## **Comments on the Applicant's Responses to the Examining Authority's Written Questions.**

Unique Reference Number: 20040614

On the 10<sup>th</sup> October 2023, I submitted my "Written Representation to the Examining Authority regarding the Environmental Statement submitted by Tritax Symmetry (Hinckley) Ltd in respect of their proposed Hinckley National Rail Freight Interchange and with particular reference to Chapter 10: Noise and vibration."

NMP4

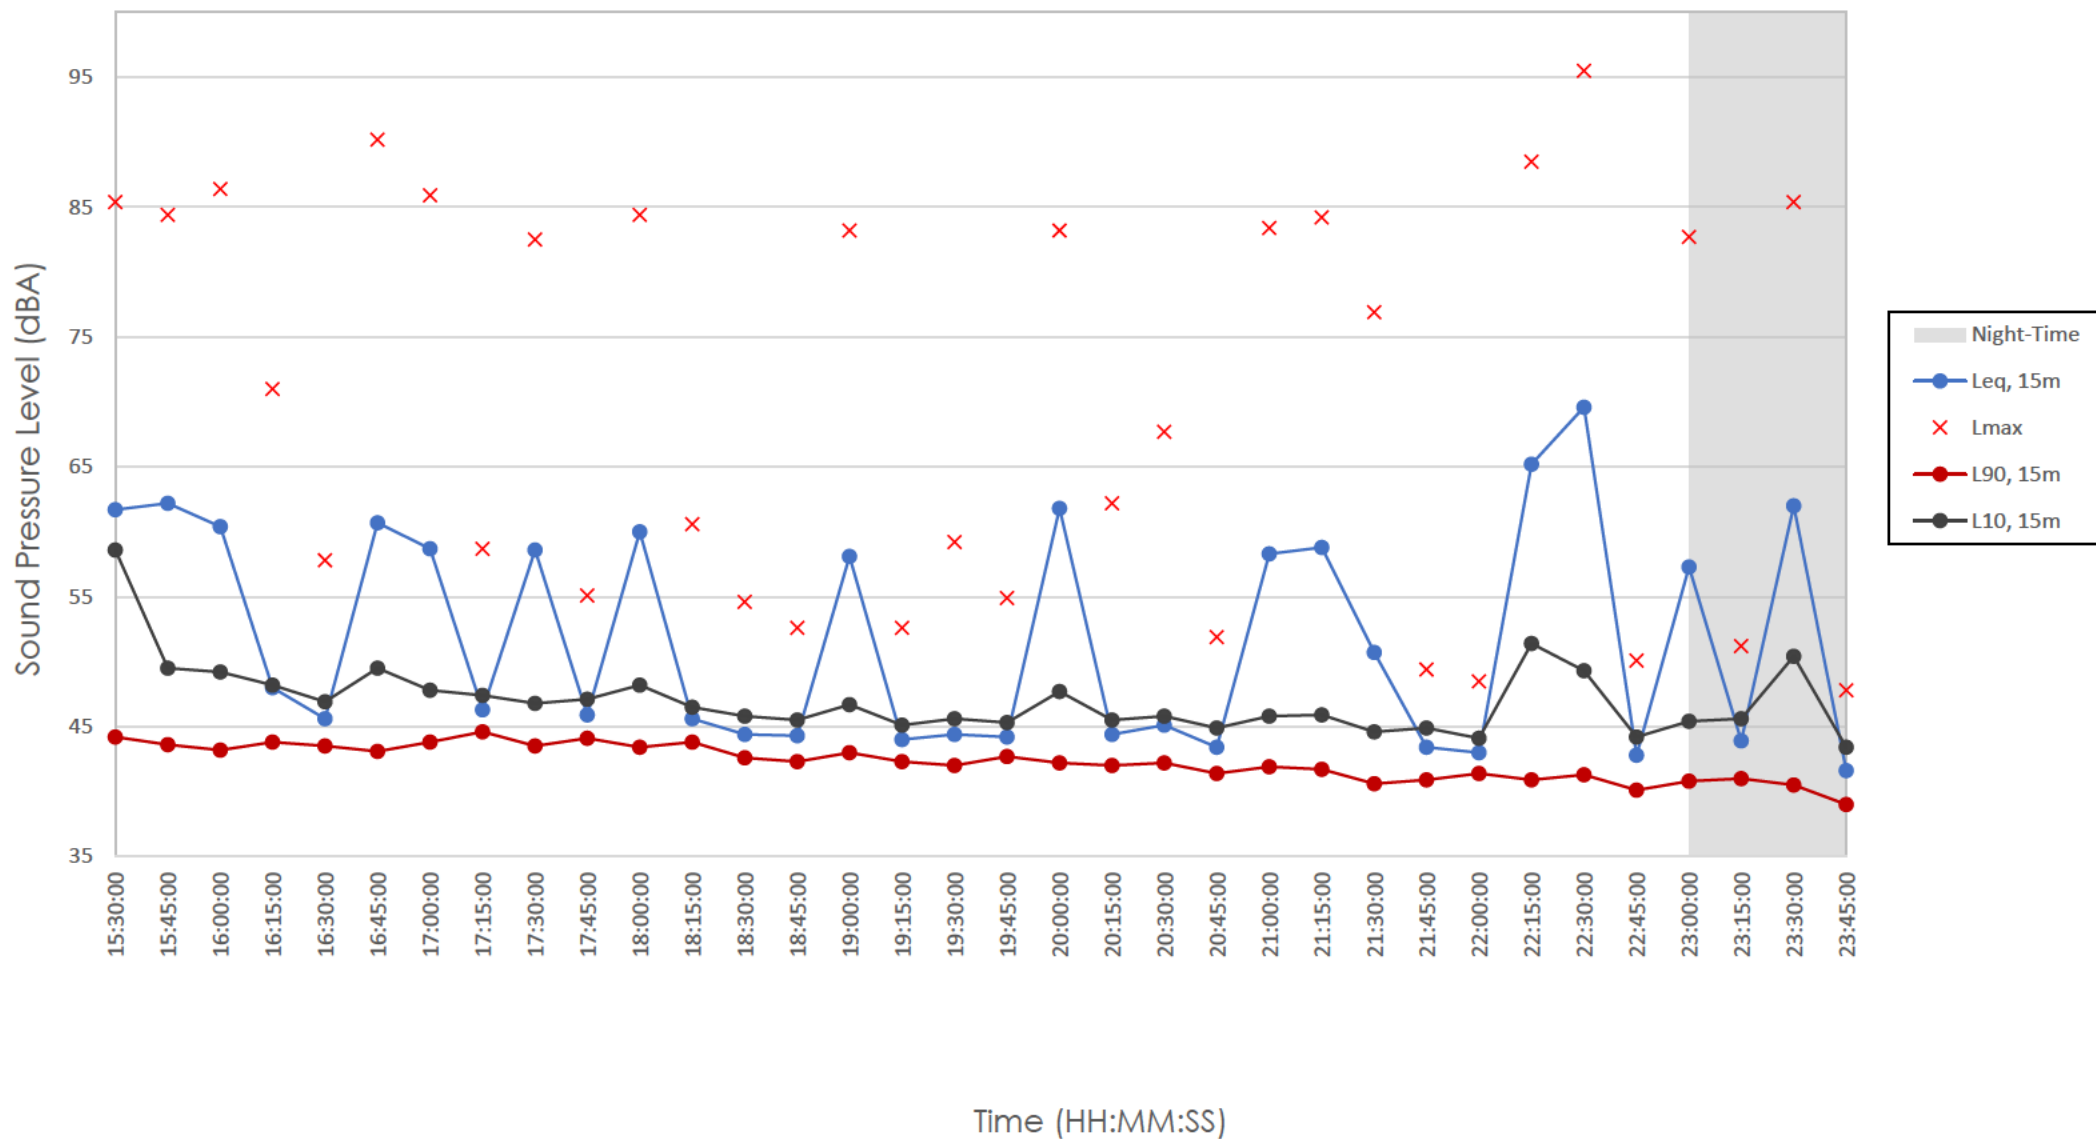
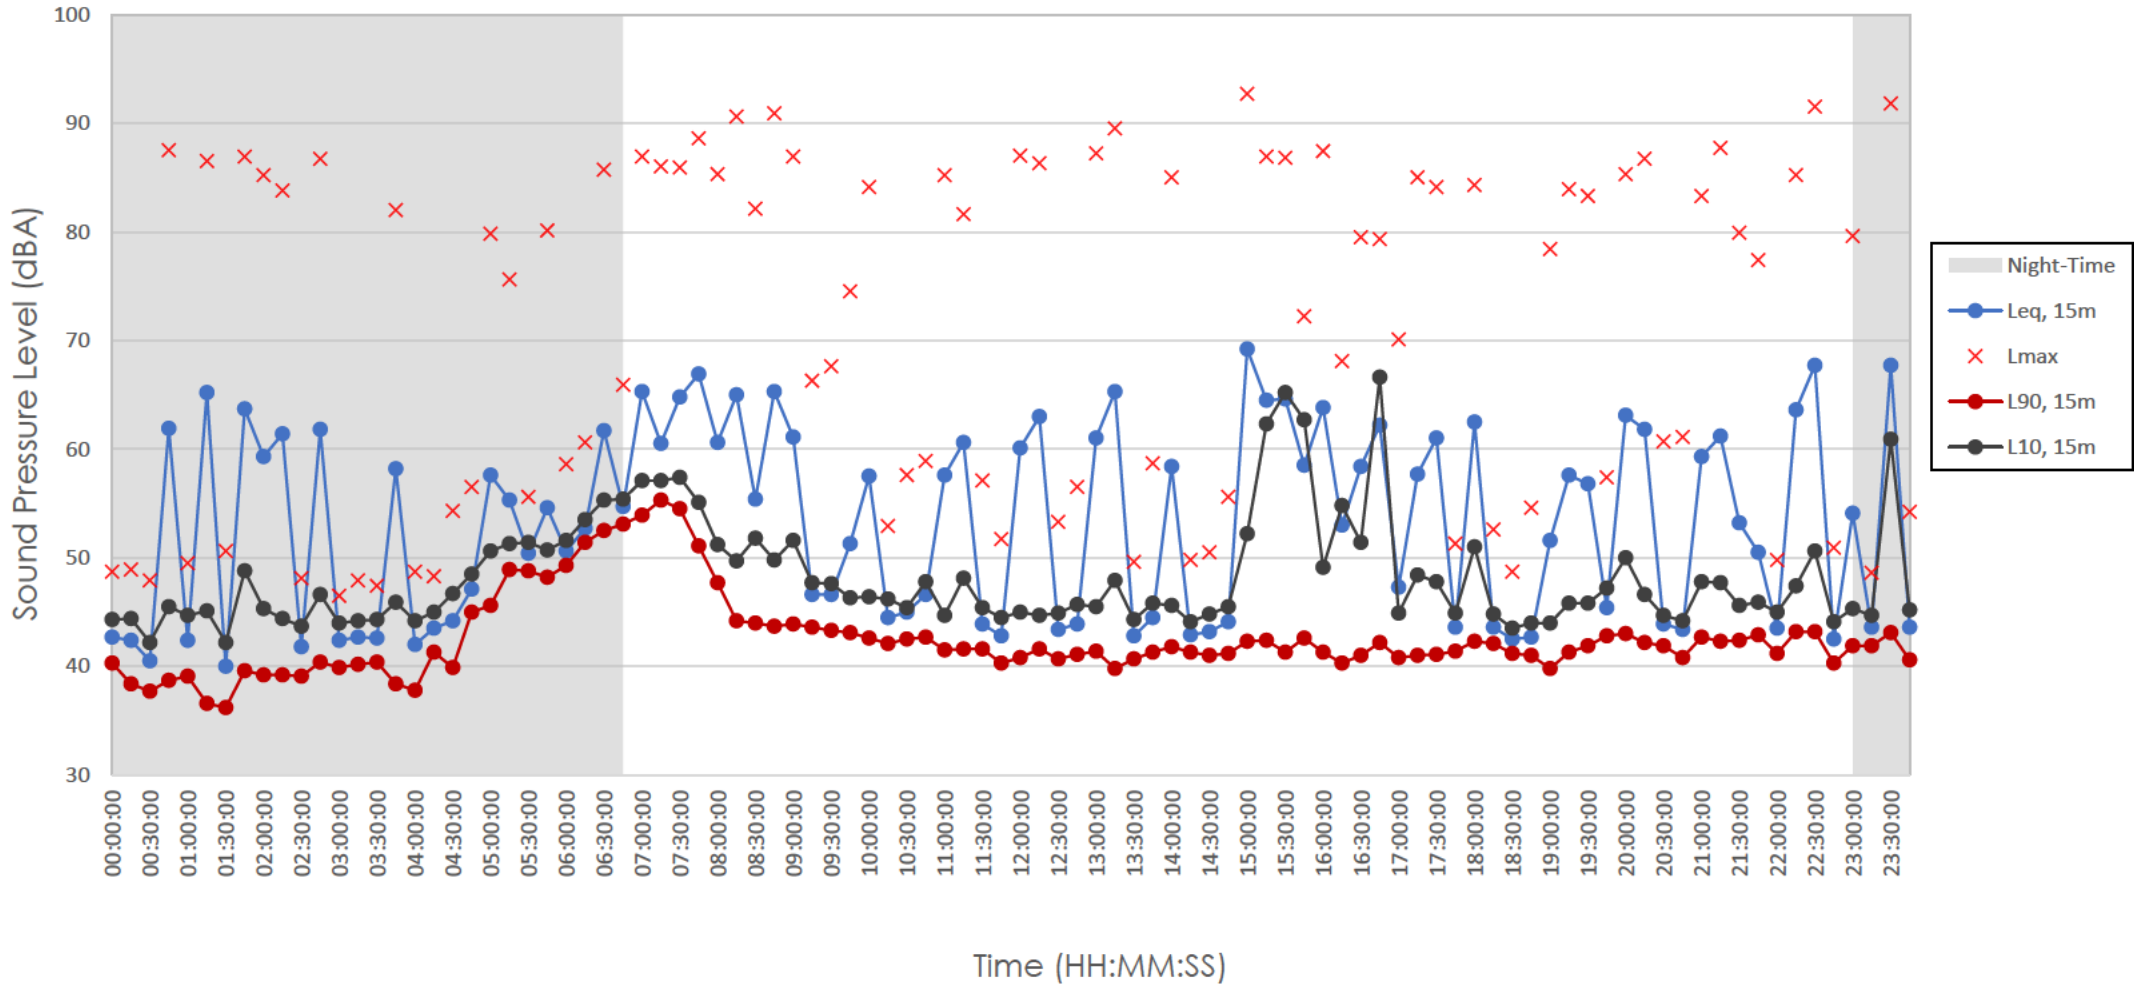
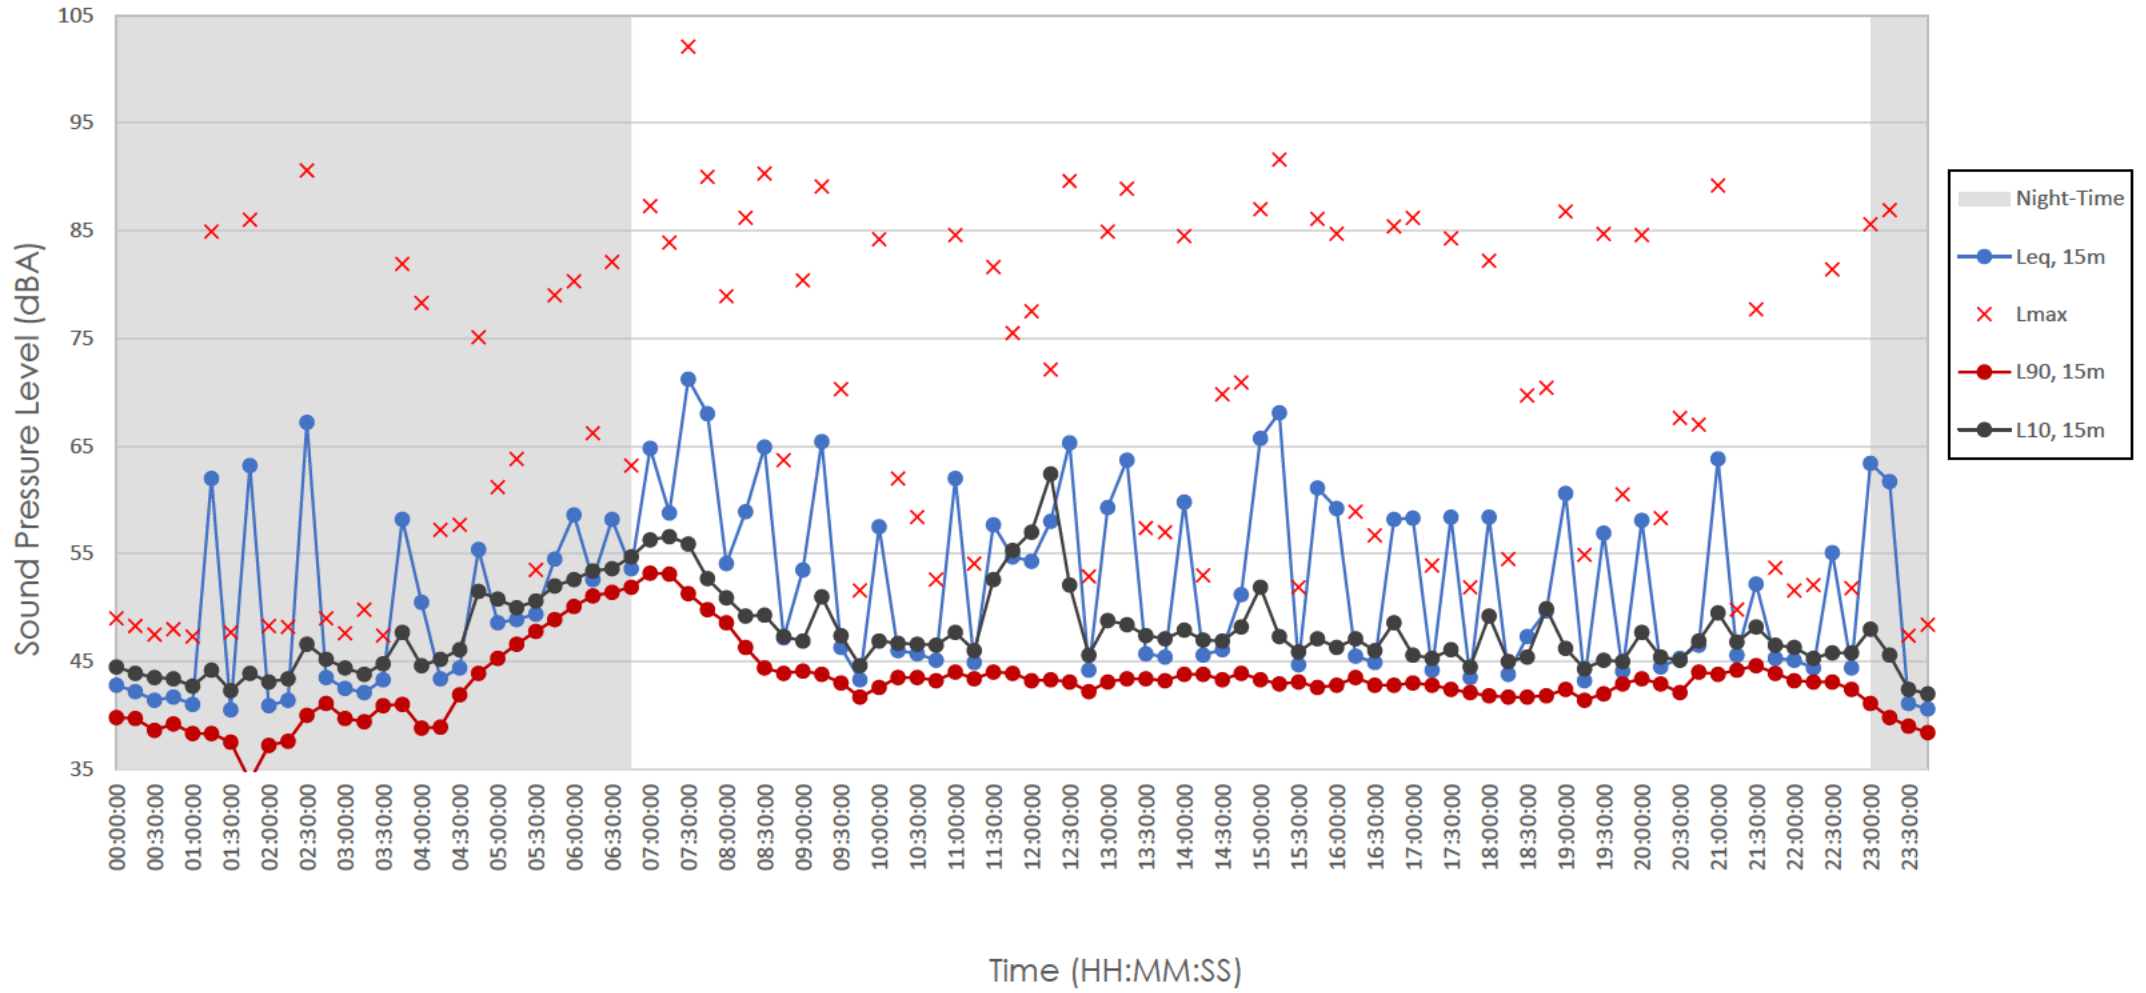
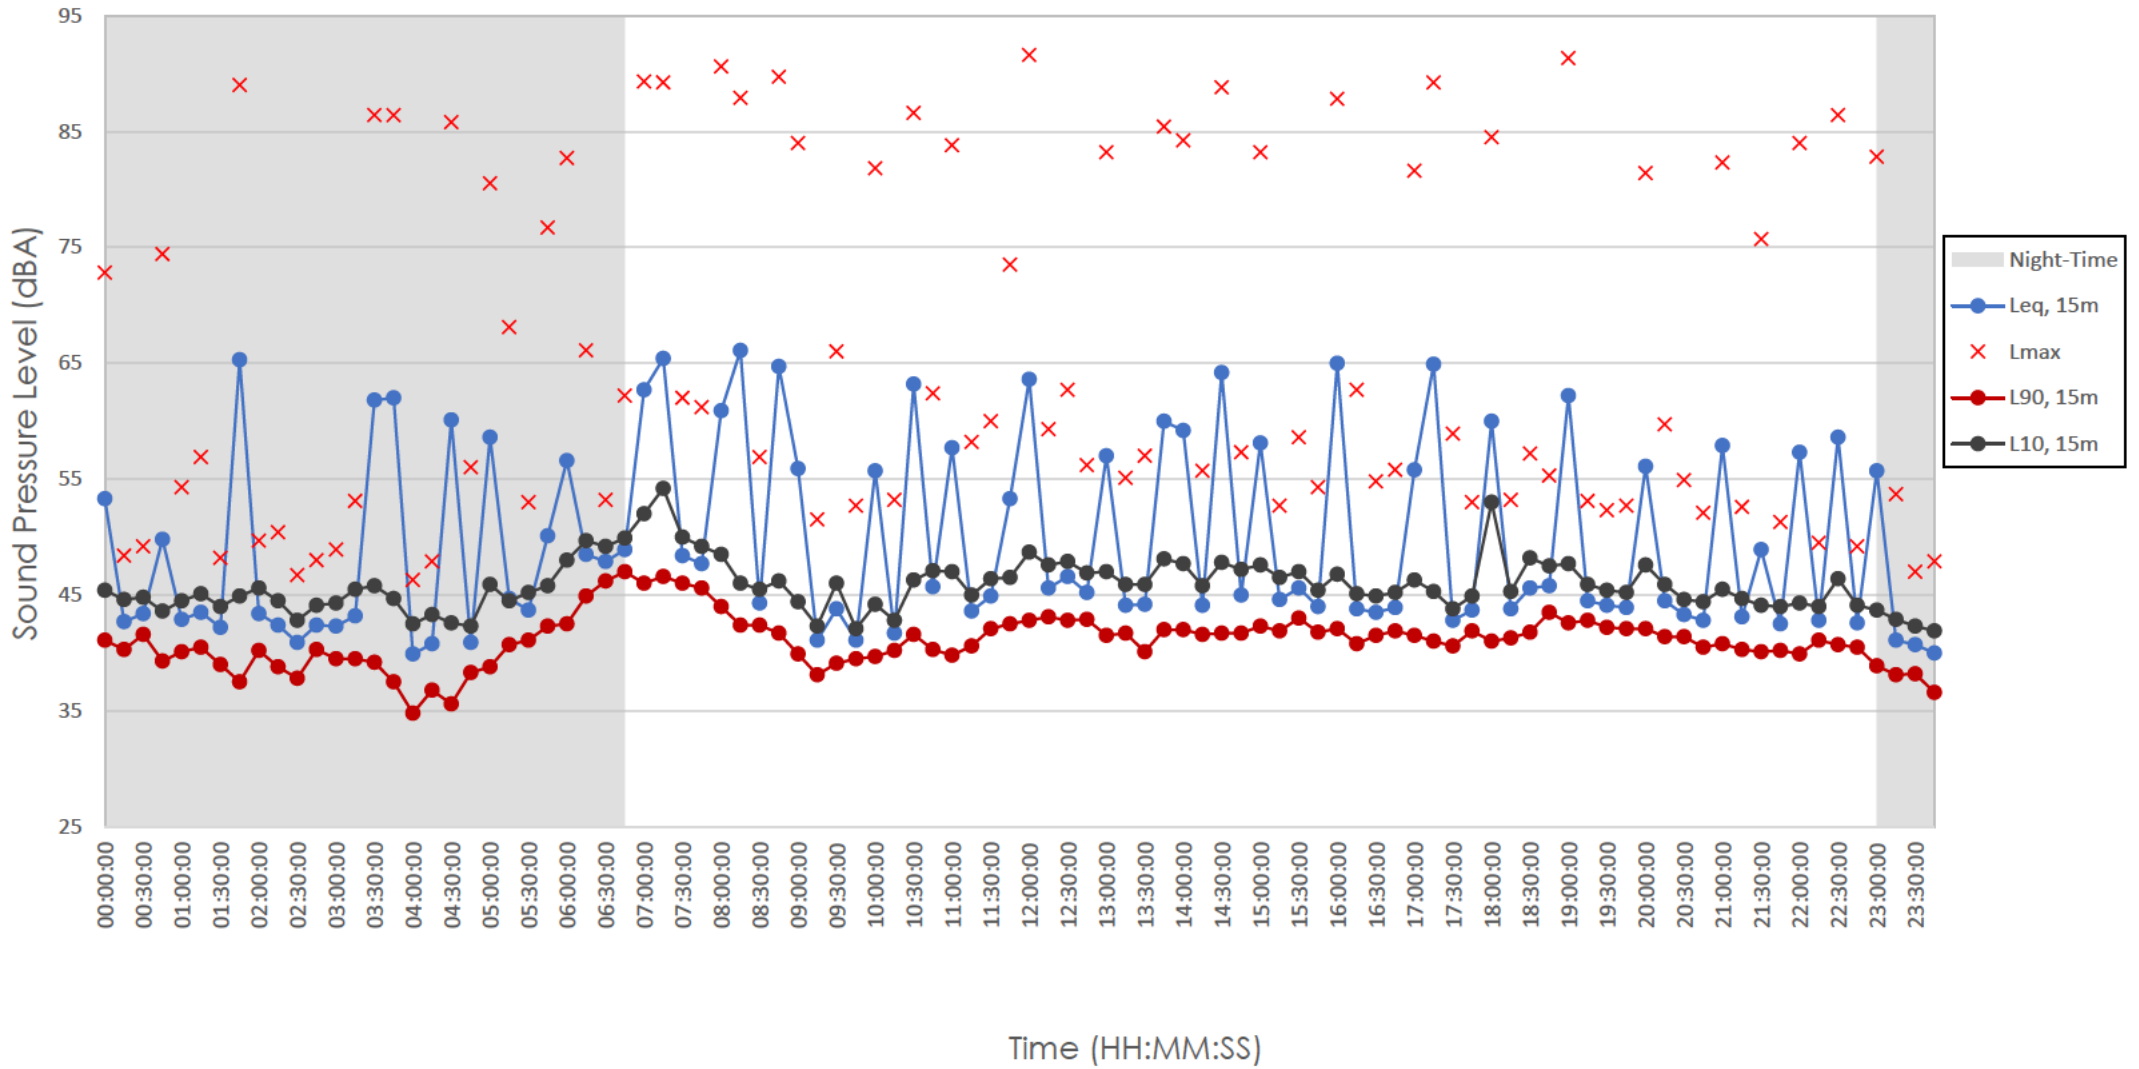
In their Noise and vibration report proper, Tritax measured Rail Noise at Noise Monitoring Position NMP4 at the trackside over a continuous period of some seven days. As such, that measured data may be viewed as the “Gold Standard” and together with the data from the other NMPs forms a foundation of Tritax’s report.

The Rail Noise data that Tritax seek to introduce in their Update Note is however ***very much higher*** than the NMP4 data Tritax measured in their Noise and vibration report.

But it’s when you actually come to look at the dB values in the Table Keys that the alarm bells really start to ring. For example, in Figure 2, the boundary between the orange and the yellow bands is indicated at 55.0dB. But this is almost the same night-time Noise level of 56.3dB that was measured at NMP4 at a location just 12 metres from the track!

Further analysis indicates that in comparison with the precise “Gold Standard” Noise measurements performed at NMP4 over a period of seven days, the data in Figures 1 and 2 overstates the Train Noise levels by approximately 12dB during the daytime, and rather more at night-time. So the values in the dB Keys in Tritax’s Figures 1 and 2 need to be adjusted downwards by 12dB accordingly.
